From: Roger Spencer
Sent: 12 February 2018 11:35
To: Richard Temple
Subject: FW: Ref Planning Application FP/268/17/PL

Timber Planks to be fixed without gaps, to the timber posts, sitting on top of the existing seawall.

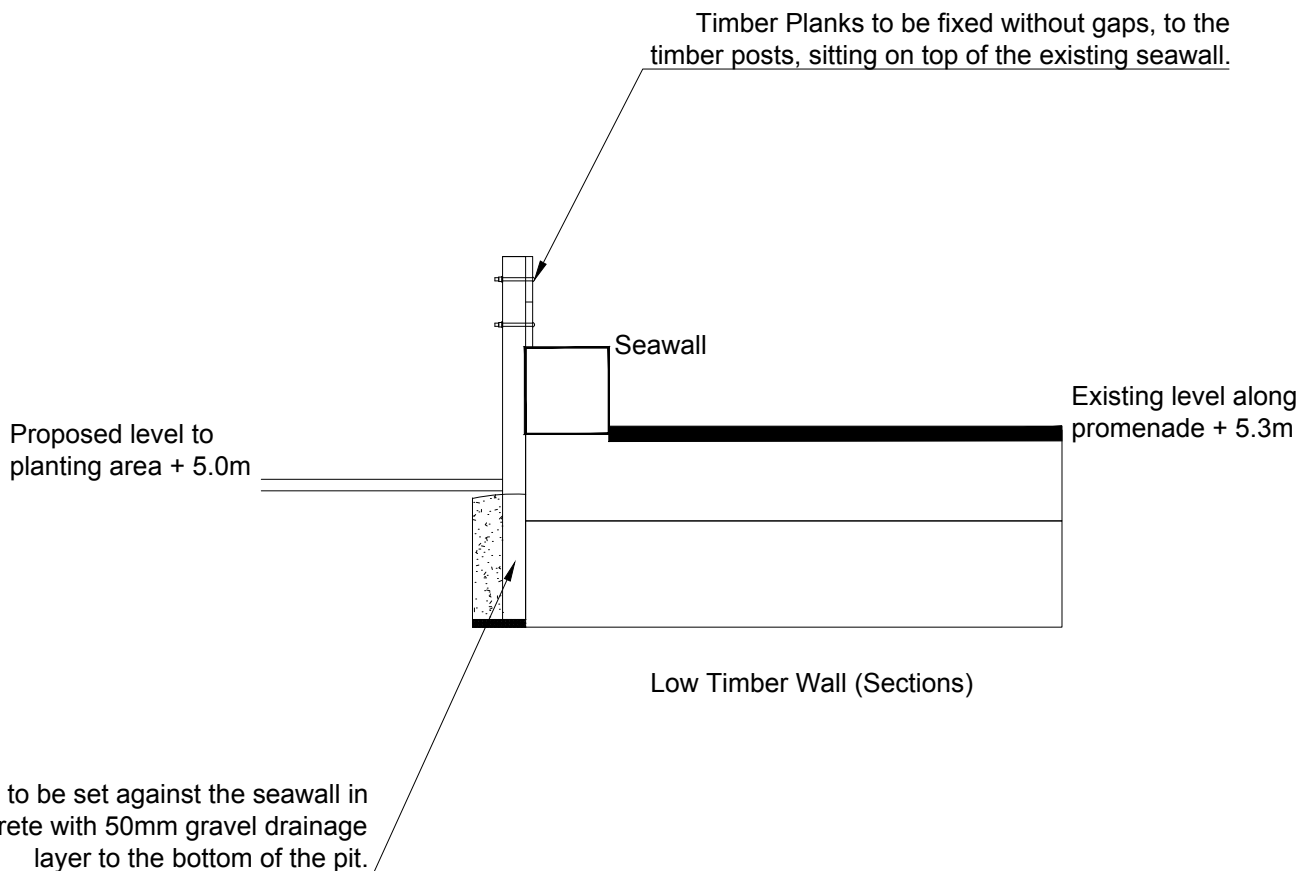
I note that you have shown 2 No. 300mm high (x 50mm wide) planks to make up that 600mm. The 300mm width is not usually an economic section – it may be worth considering 3 x 230mm (9”) – this would necessitate the post to be raised slightly to support the extra 90mm?? However, I consider either (600mm or 690mm above the rear splash-wall) to be reasonable.

However, I would urge you to change the min 1500mm centres to “max”

I would also suggest that you reconsider the fixing detail. As it stands, with the fence tight up against the back of the seawall, you wouldn't be able to fix the planks to the posts - suggest that you fix the posts against the wall then start the planks on top of the wall. You may have considered that we wouldn't like this encroachment over the seawall but I think it is preferable to your current detail. Sitting the bottom plank on top of the wall would also provide for a better seal too.

I assume that you'd concrete the posts into the ground, as I wouldn't want to put more loading onto our seawall by fixing into the back of it. Please also consider that digging out for the concreting in may be a little problematic – I'm not sure what the construction would have been in the 1960s when the seawall went in.
